Cottam Solar Project

Schedule of Changes (Deadline 2)

PINS Reference: EN010133
Document Reference: EX1/C8.1.7_A
The Infrastructure Planning (Examination Procedure) Rules 2010
Rule 8(1)(k)

Key:

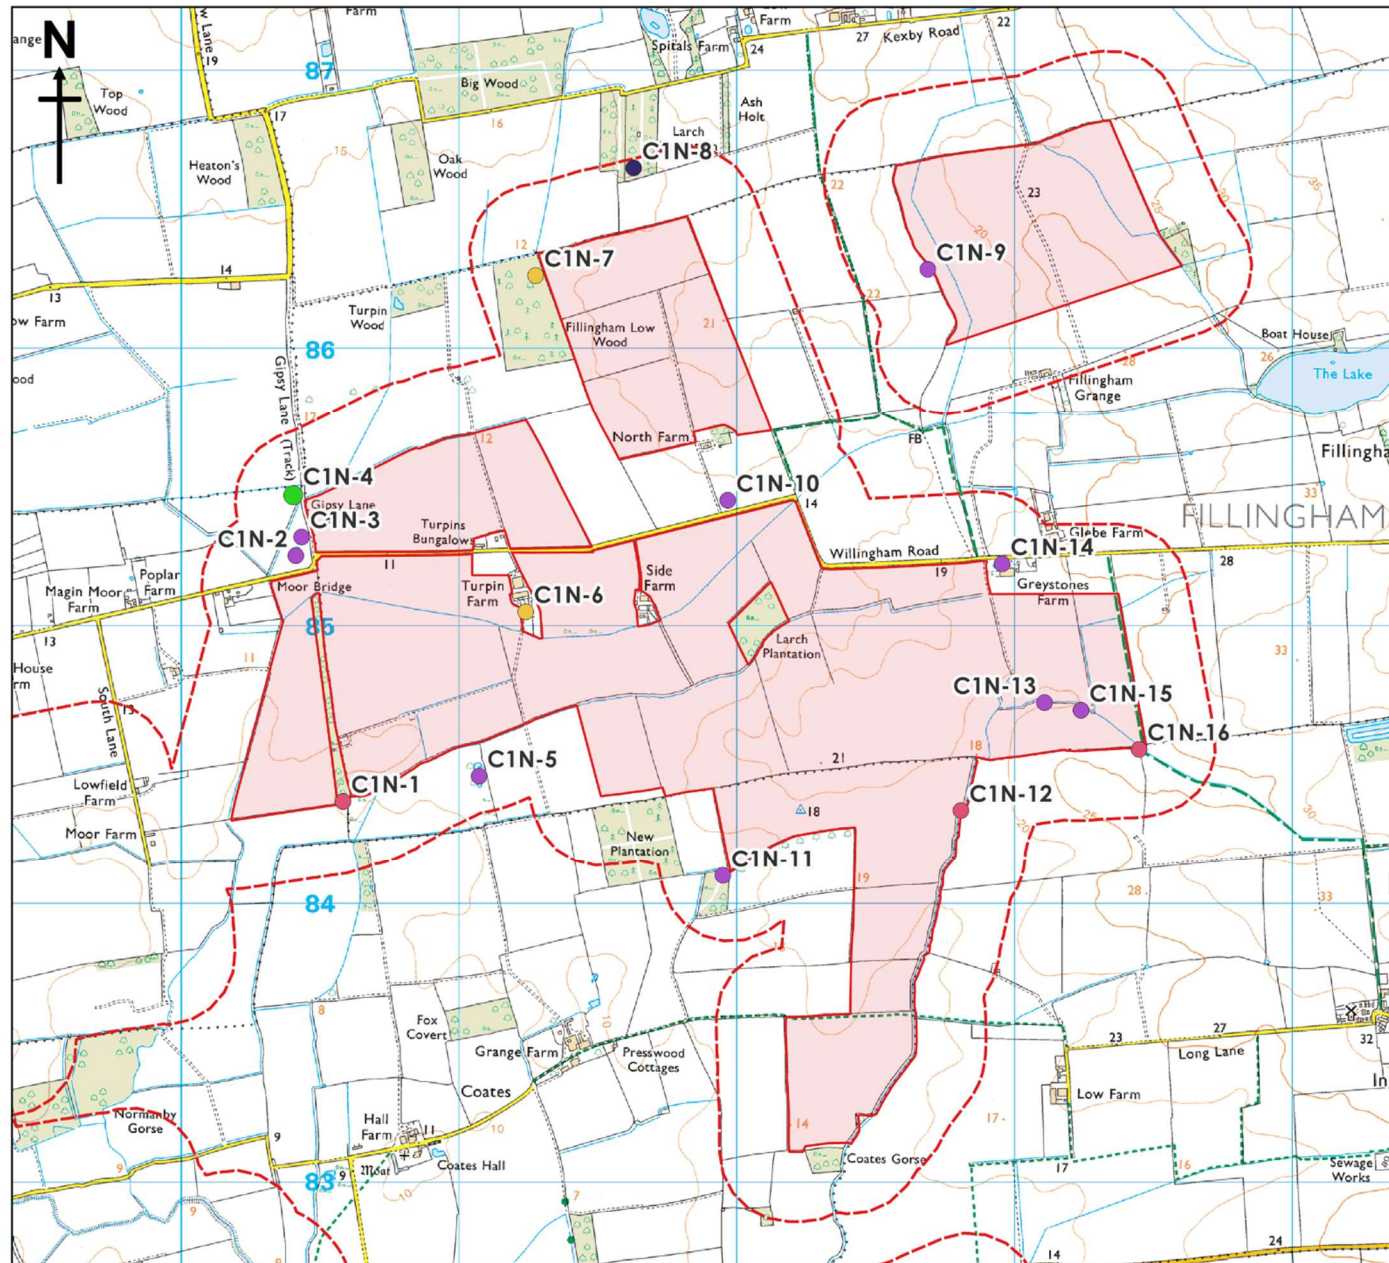
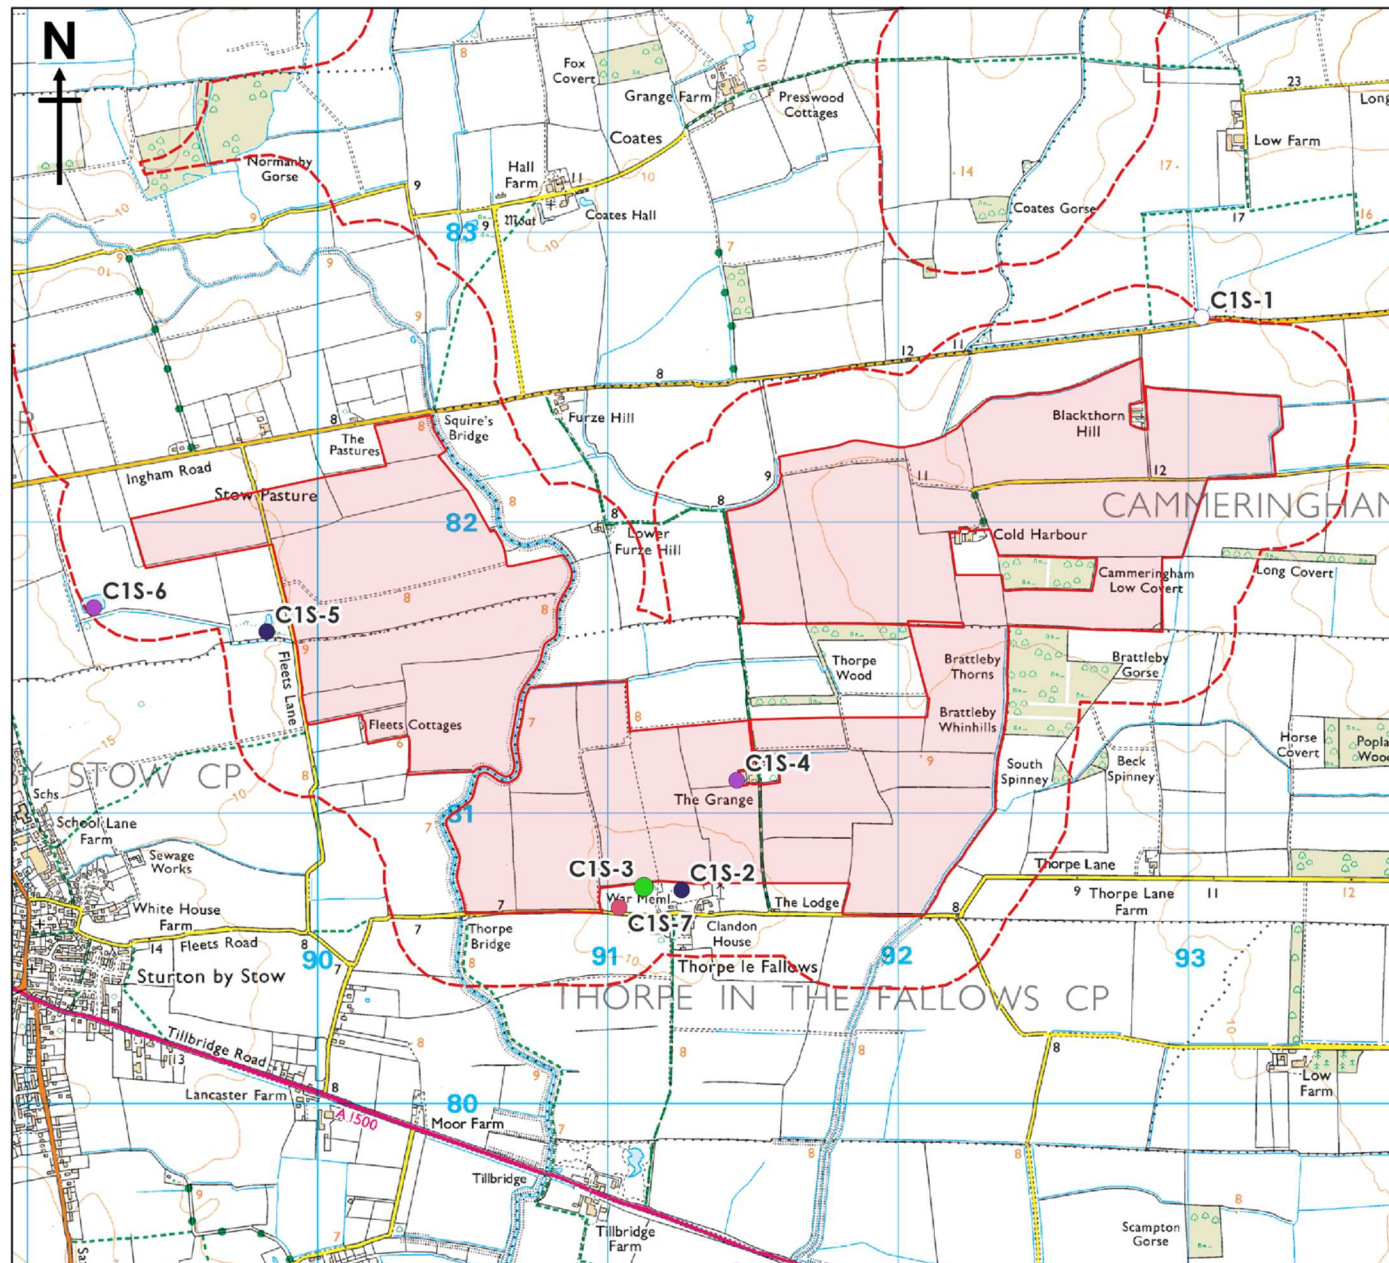
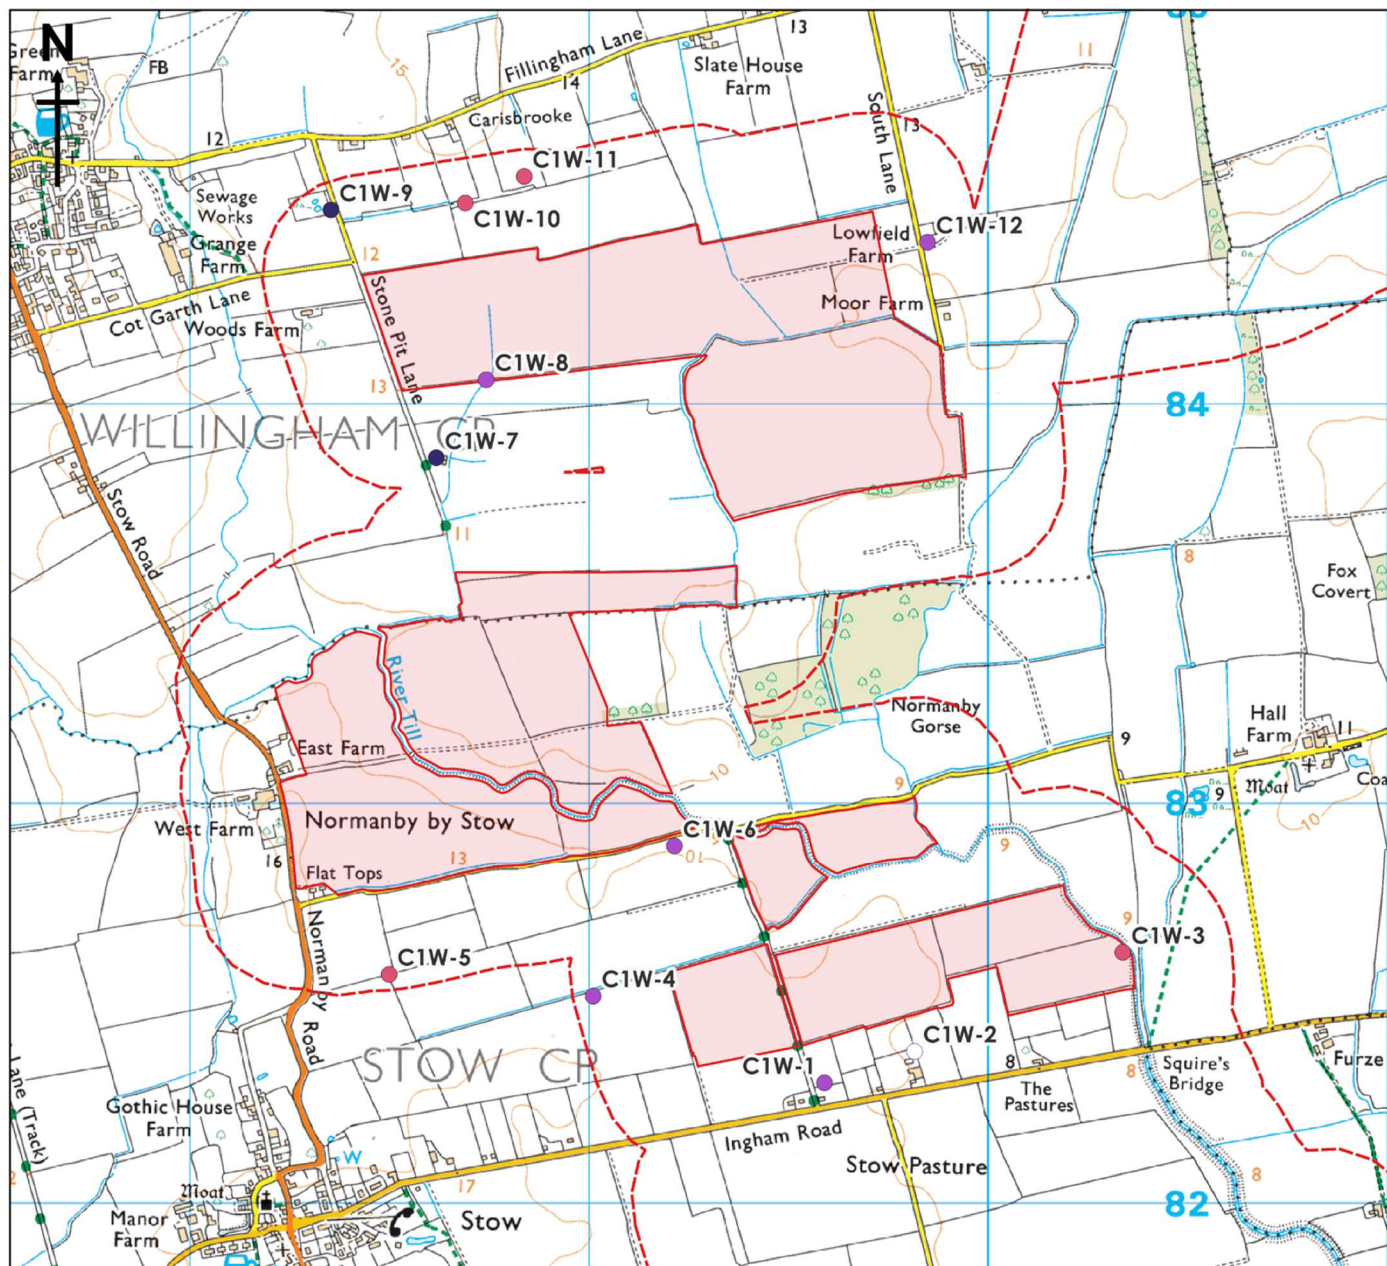
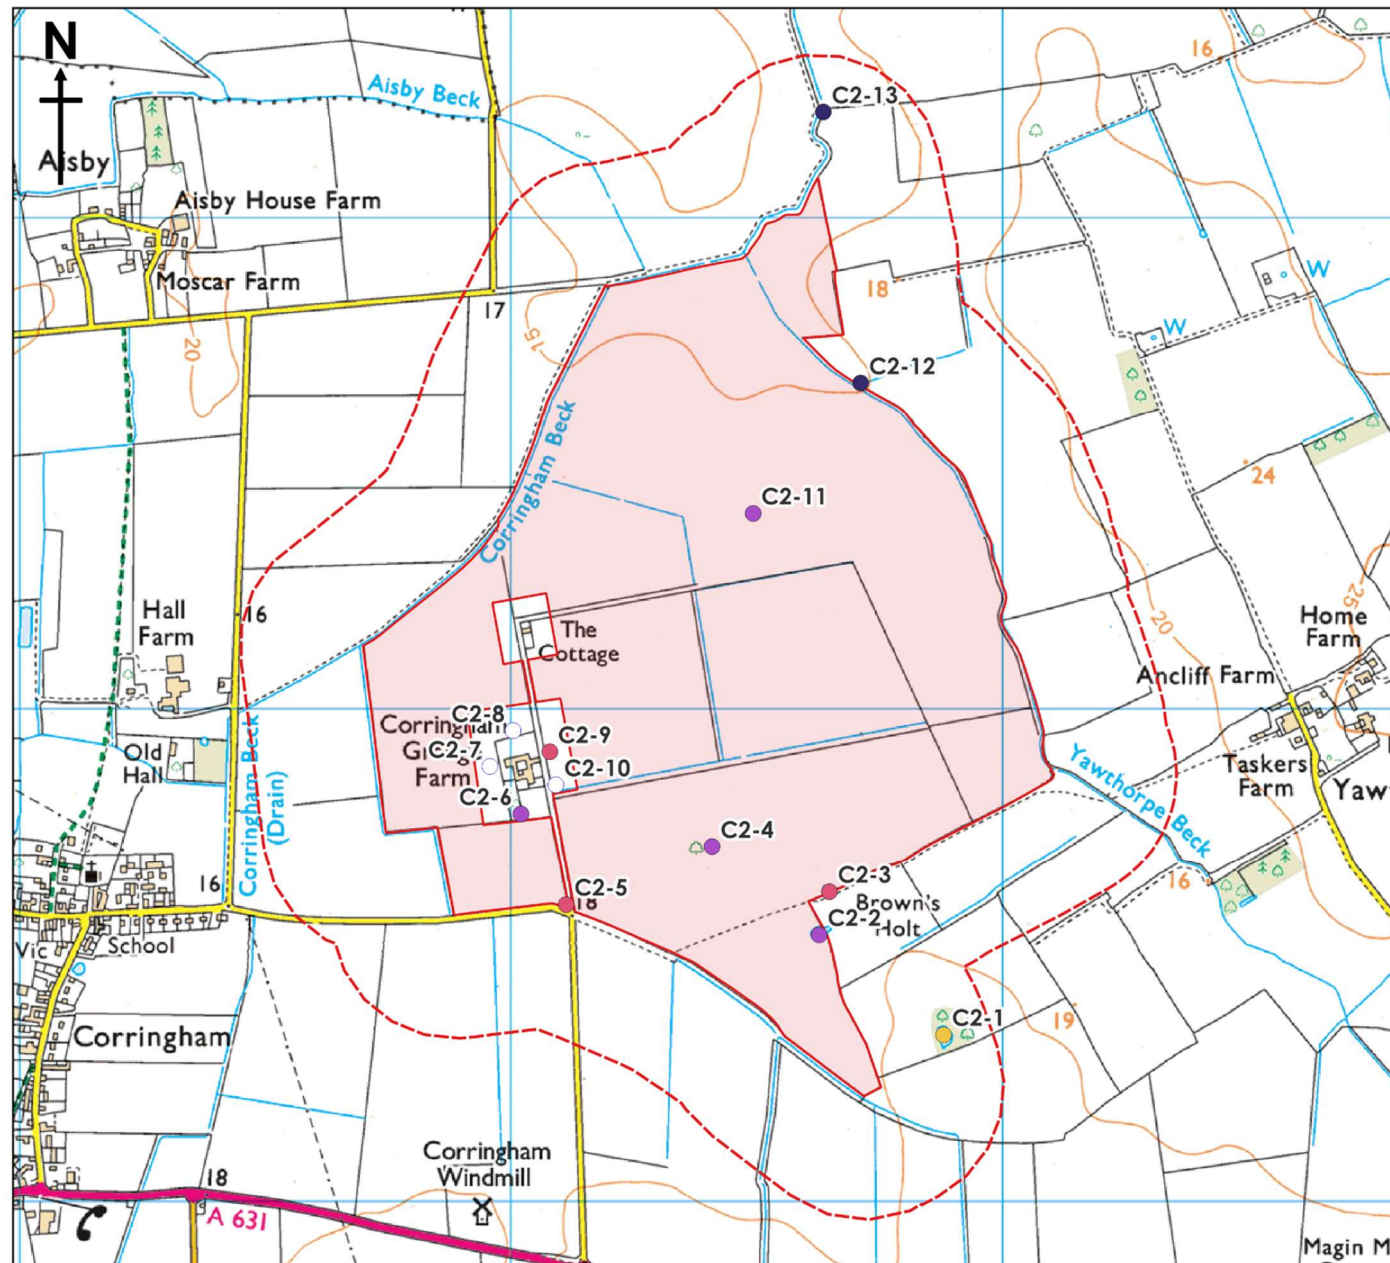
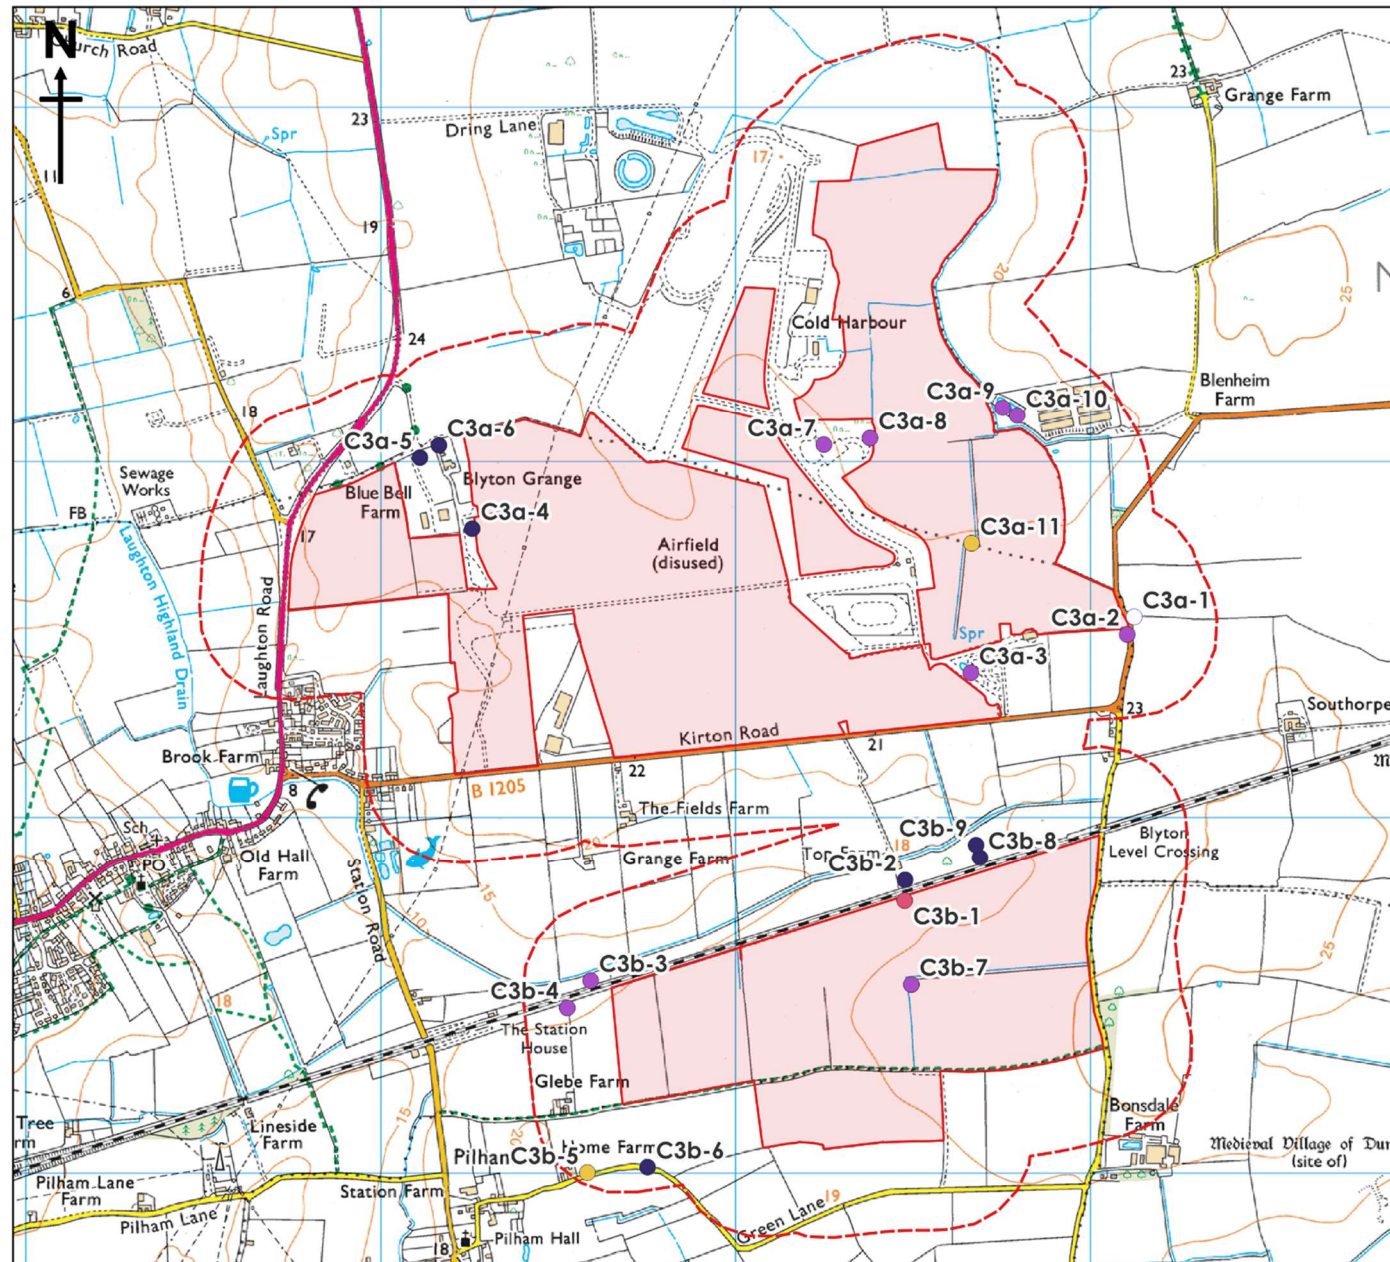
C6.3.9.7 Great Crested Newts Survey Report	[APP-084]	Revision A [EX1/ C6.3.9.7_A]	Deadline 1 17 October 2023	Paragraphs 2.2.11, 4.1.6 and Figure 11, added; Paragraph 2.2.22 deleted and Paragraphs 3.2.6, 4.1.2, 4.1.5, 4.1.7, 4.2.4 and Tables 7, 12 updated to include 2023 Great Crested Newts Survey.	To provide information on the likely presence or likely absence of Great Crested Newts for 6 additional ponds along the cable corridors where access had not been previously arranged and of a further three ponds which were previously found to be dry.
C6.3.14.2 Construction Traffic Management Plan	[APP-135]	Revision A [EX1/ C6.3.14.2_A]	Deadline 1 17 October 2023	Construction Traffic Management Plan updated to take equestrians and reinstatement of private roads into account.	ExA Request ISH1 and to address the British Horse Society's Relevant Representation [RR-023].
